<b>TO:</b>	Jean Fraser, Planner	<b>DATE:</b>	1/25/2018
<b>FROM:</b>	Michael Guethle, PE; Ryan Wingard, PE	<b>PROJECT NO.:</b>	13982A
<b>SUBJECT:</b>	Bramhall St. - 22; MMC East Tower and Visiting Parking (PEZ.2017.289)

Wright-Pierce has reviewed the Level III Site Plan Application information provided for the East Tower and Visiting Parking redevelopment proposed at 22 Bramhall Street. The project will include adding three levels of parking to the existing parking garage, relocating the heliport to the East Tower, and adding 2 floors to the East Tower. The work will add 0 square feet of new impervious surfaces, will add 0 square feet of new building surfaces, will add 225 parking spaces, and will add 137,961 square feet of building floor area.

EXISTING CONDITIONS SURVEY
 OF: **MAINE MEDICAL CENTER CAMPUS**
 GILMAN ST., CONGRESS ST., BRAMHALL ST., ET AL
 FOR: **MAINE MEDICAL CENTER**
 22 BRAMHALL ST
 PORTLAND, MAINE 04101

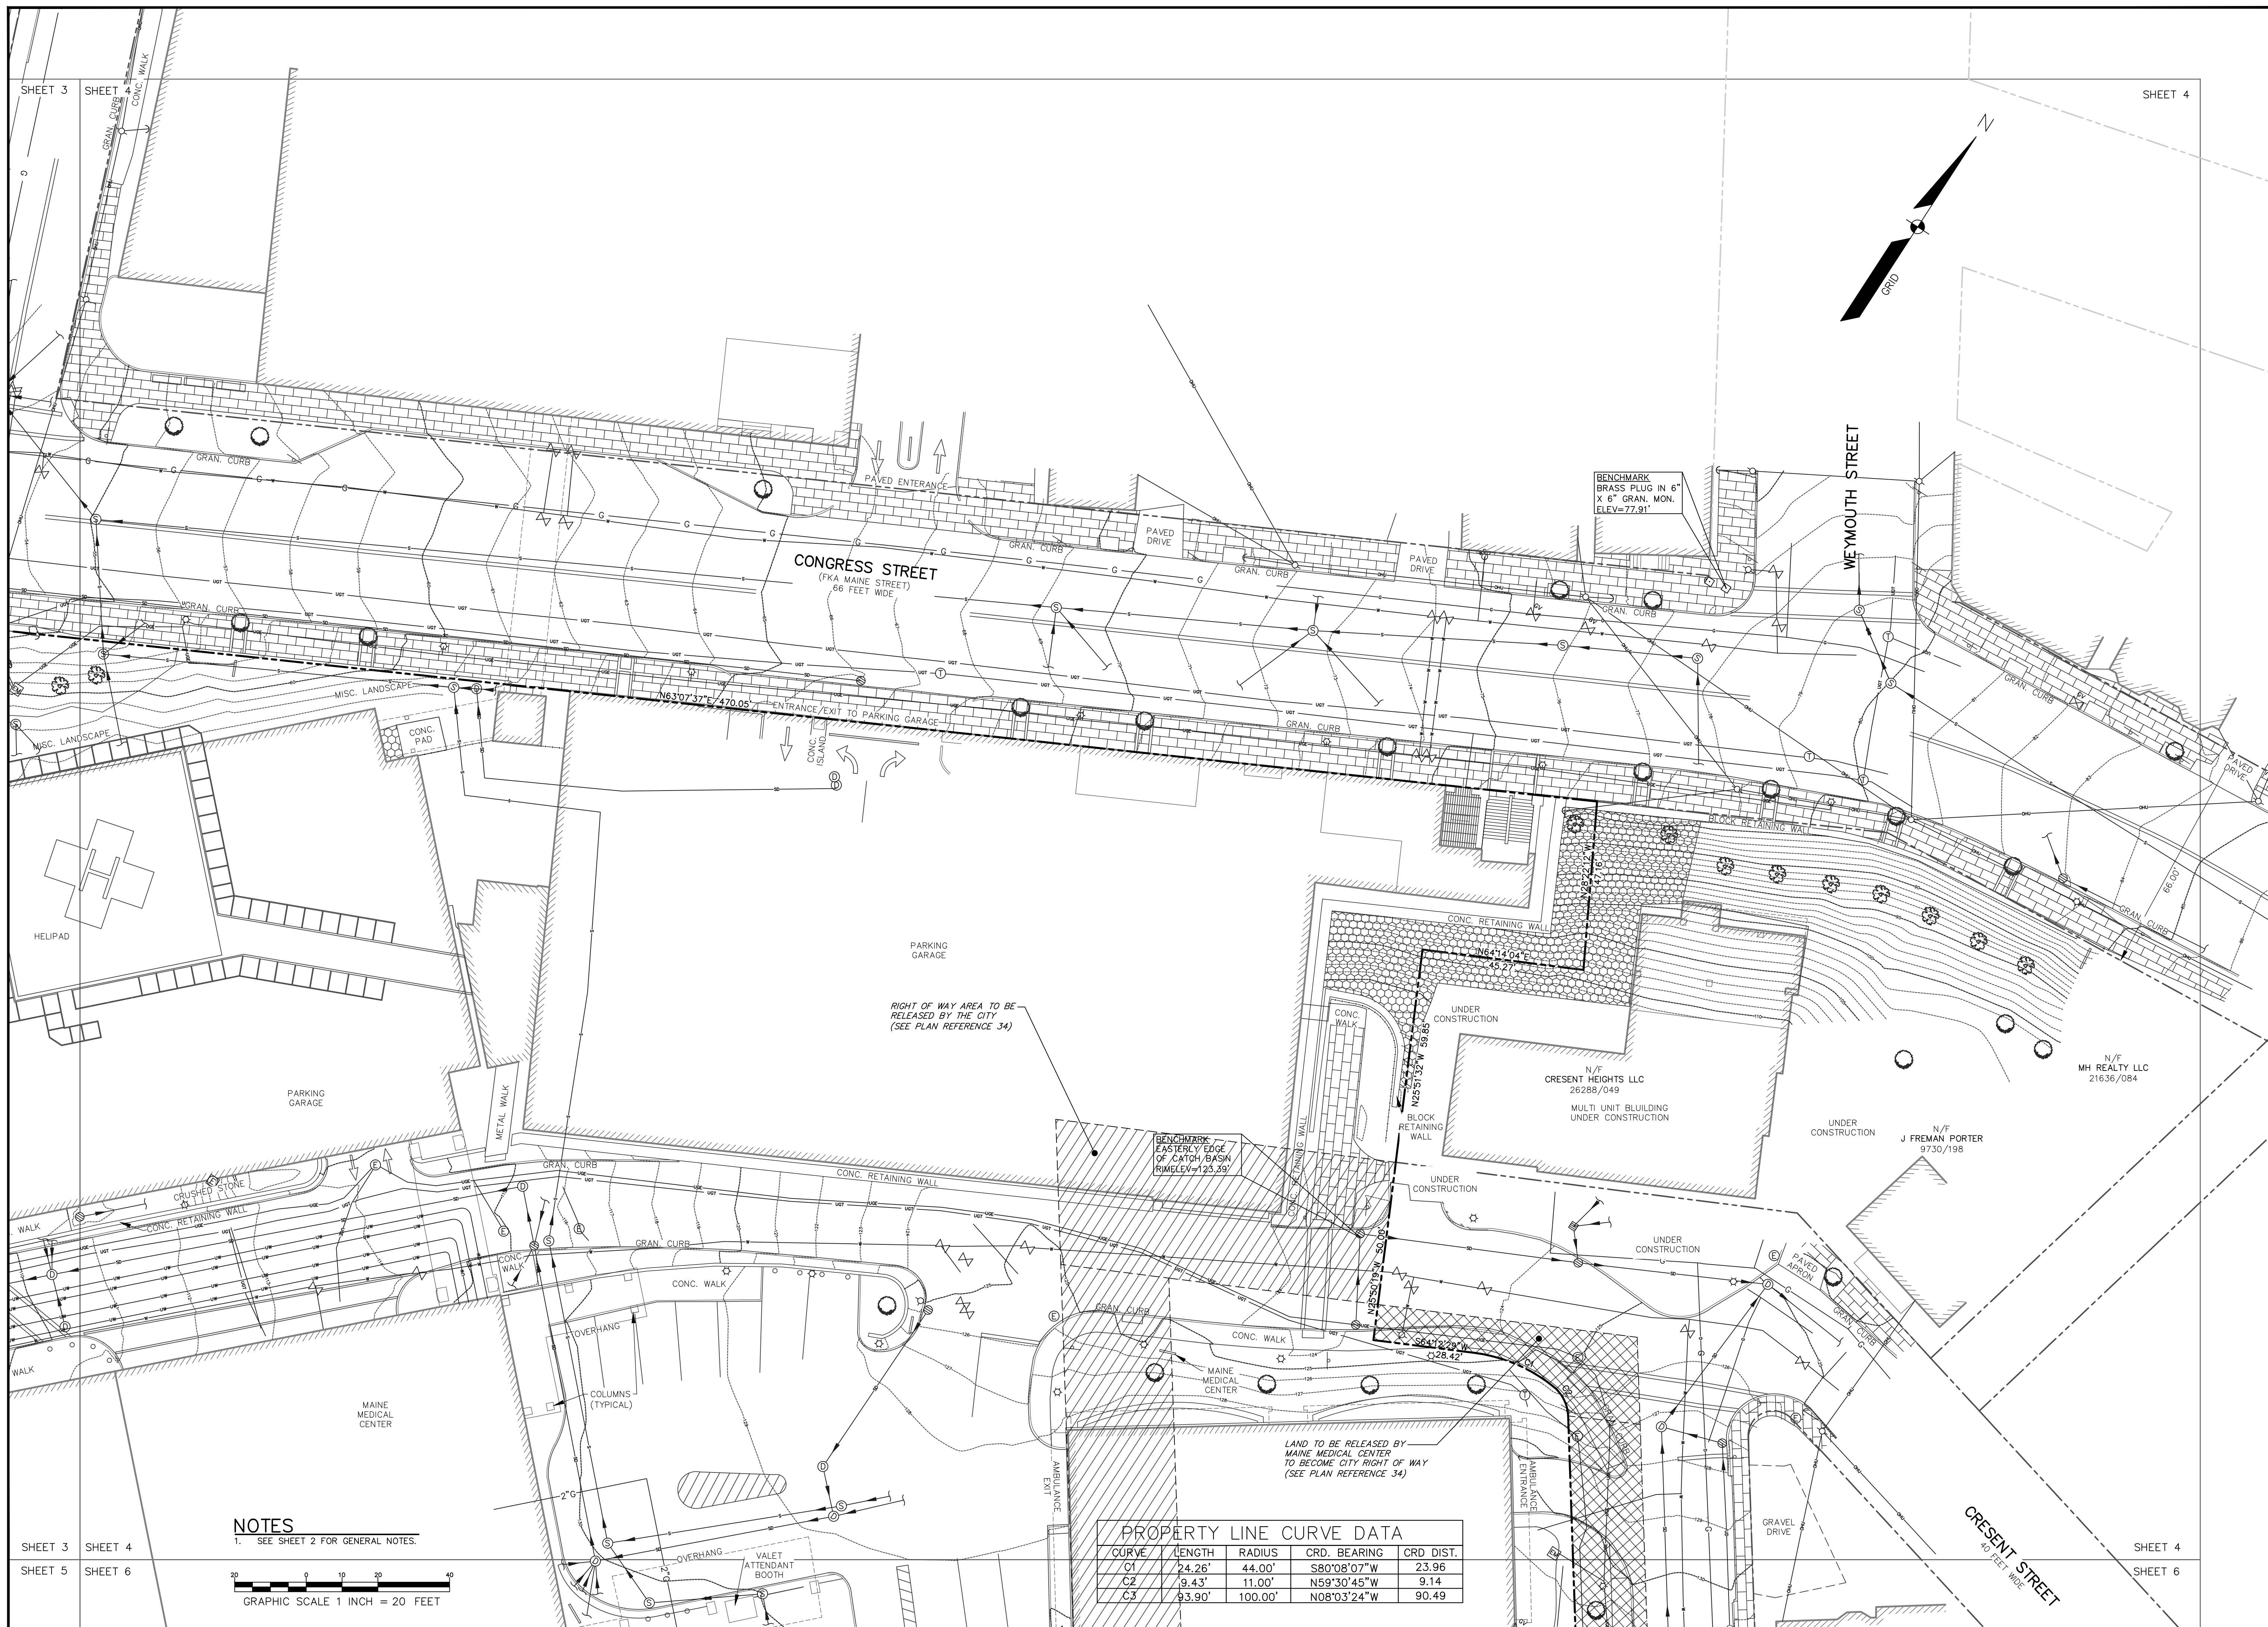
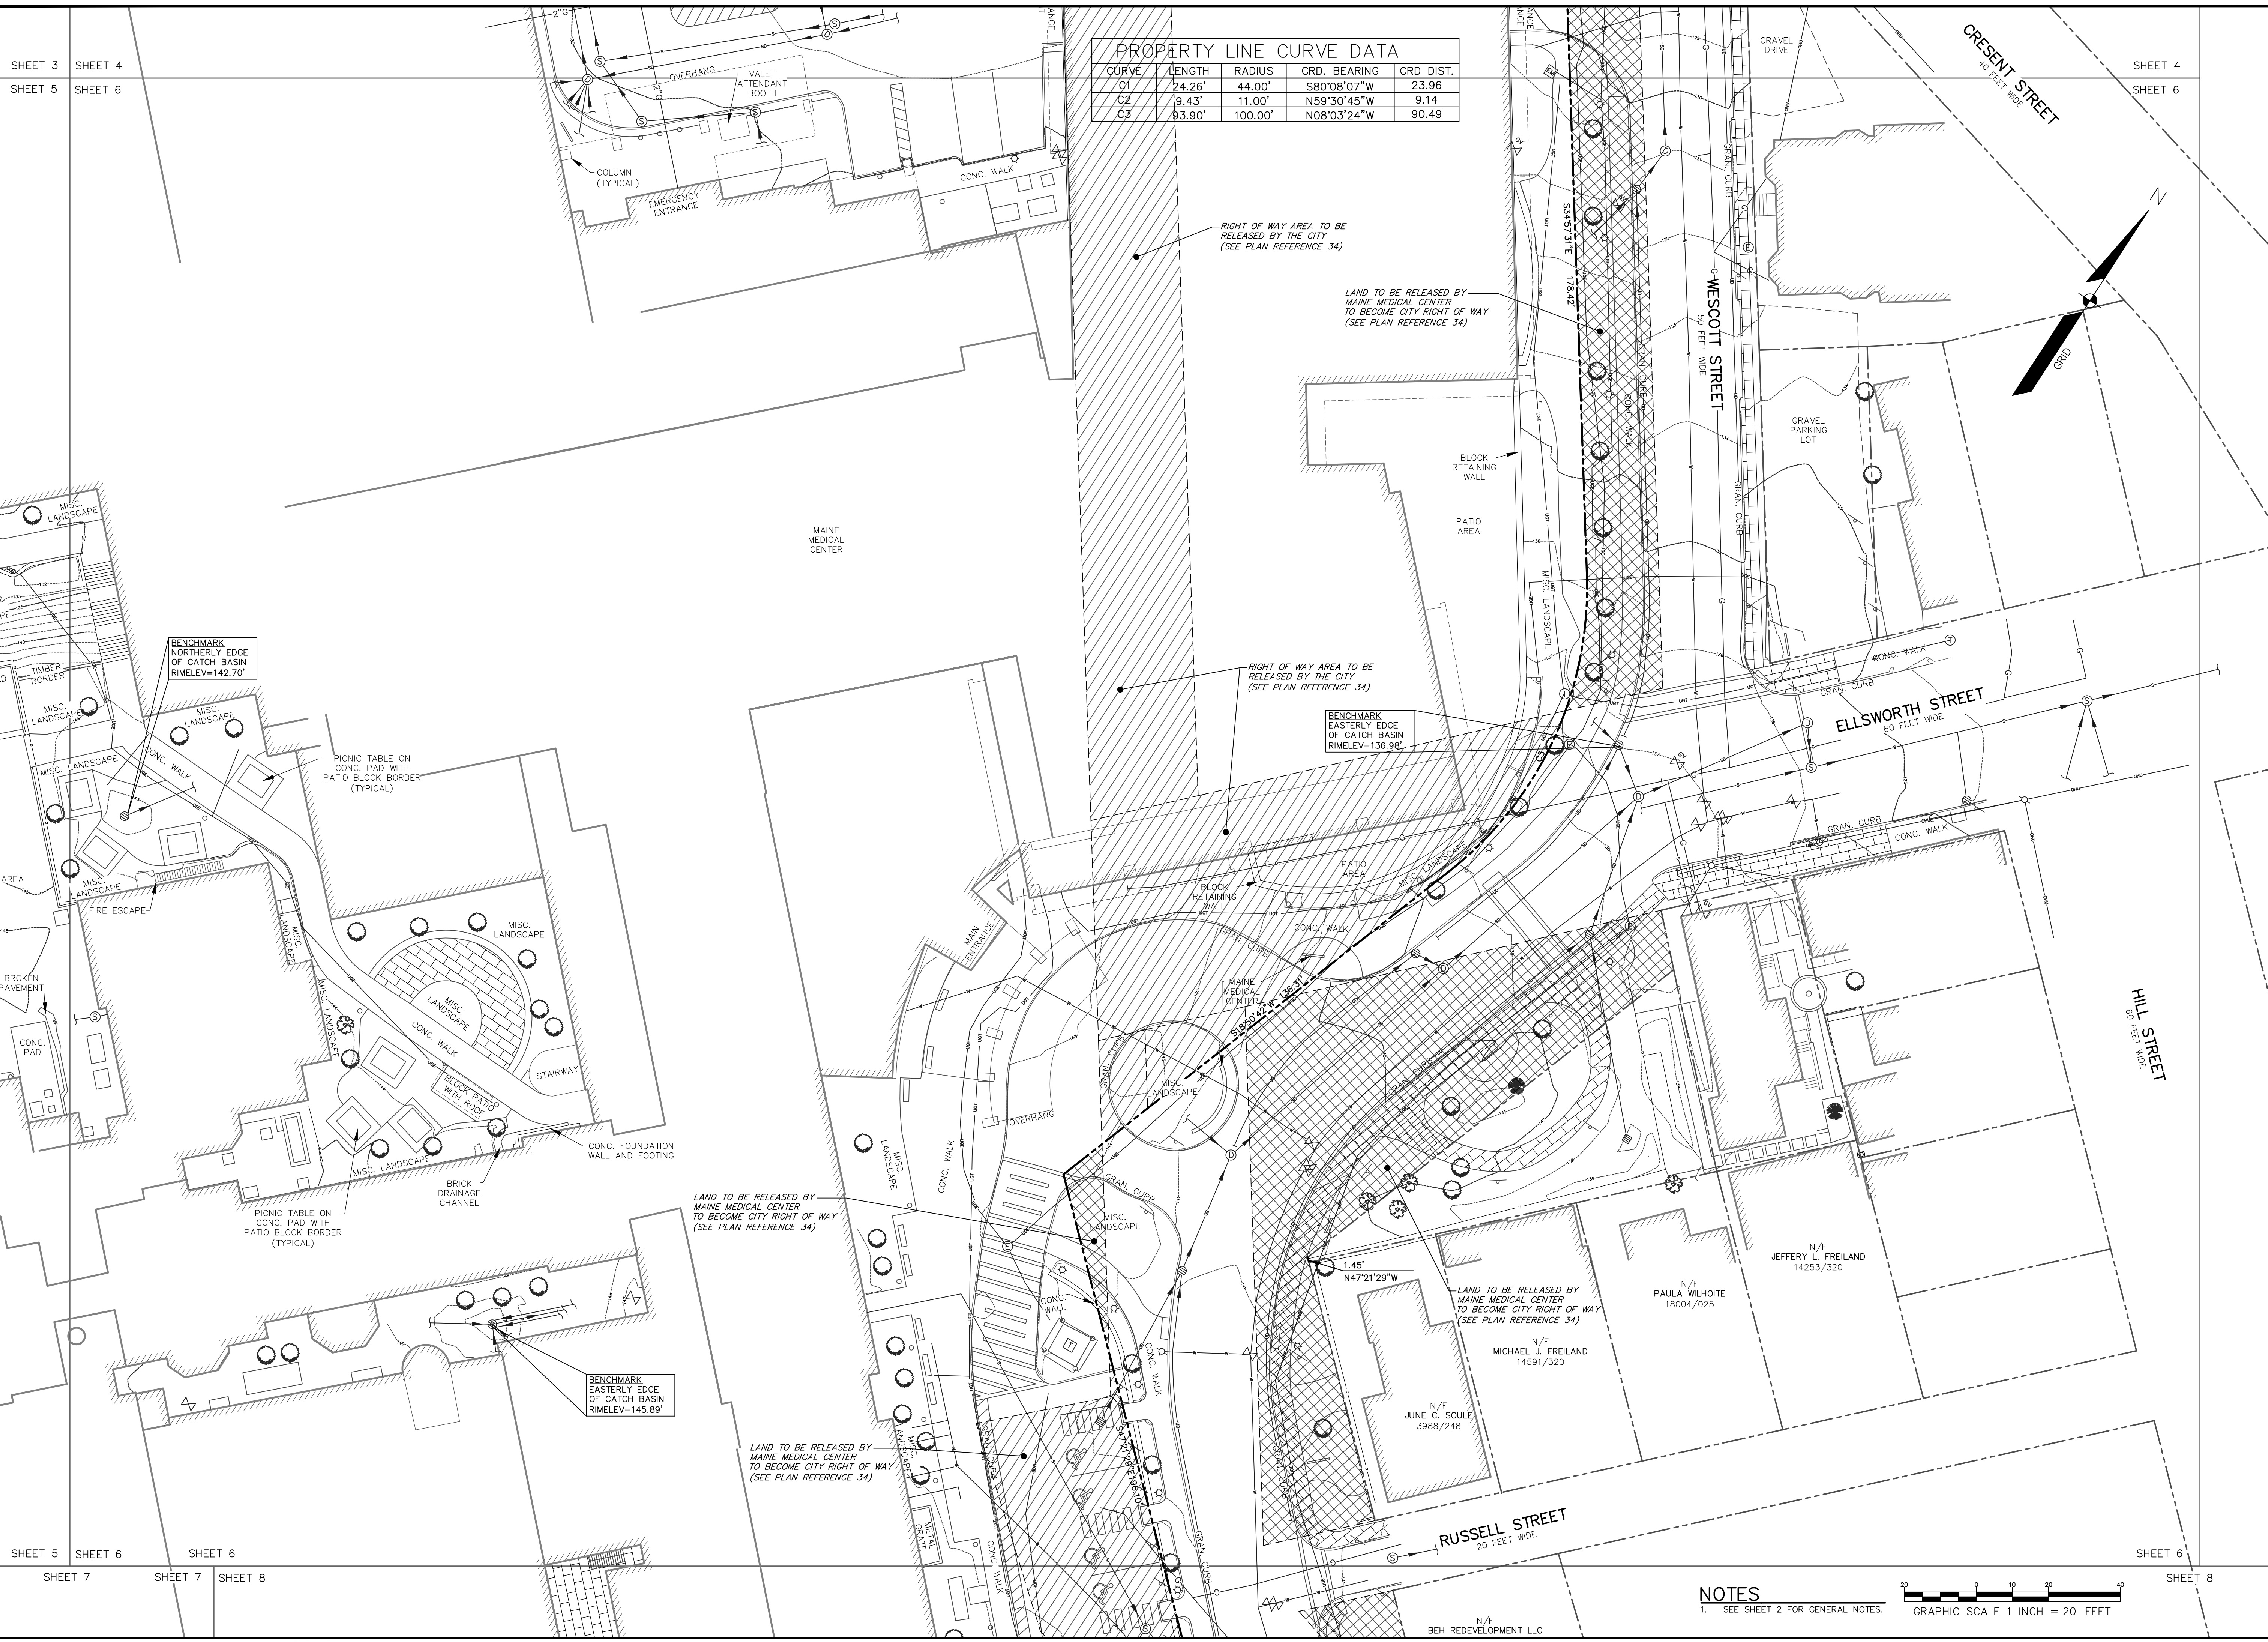
- ii. Plan 2D Boundary Survey indicates a connection or stub connection leading from the catch basin on the south side of the Visitor Garage that may allow for connection from the Visitor Garage roof drain into the separate storm drain system. The applicant shall provide the following:

1. An updated boundary survey in the vicinity of “Plan 2D Boundary Survey” with utility elevations, pipe sizes, and pipe materials in accordance with the City’s Chapter 14 and Technical Manual requirements for a Boundary Survey. Anecdotal information regarding the difficulty for construction in this corridor was discussed in the February 1 meeting. However, a sewer pipe crossing currently exists in this corridor, as does a storm drain or storm drain stub. City staff need additional information regarding existing utilities to confirm if a connection to the separate storm drain will be feasible or not.
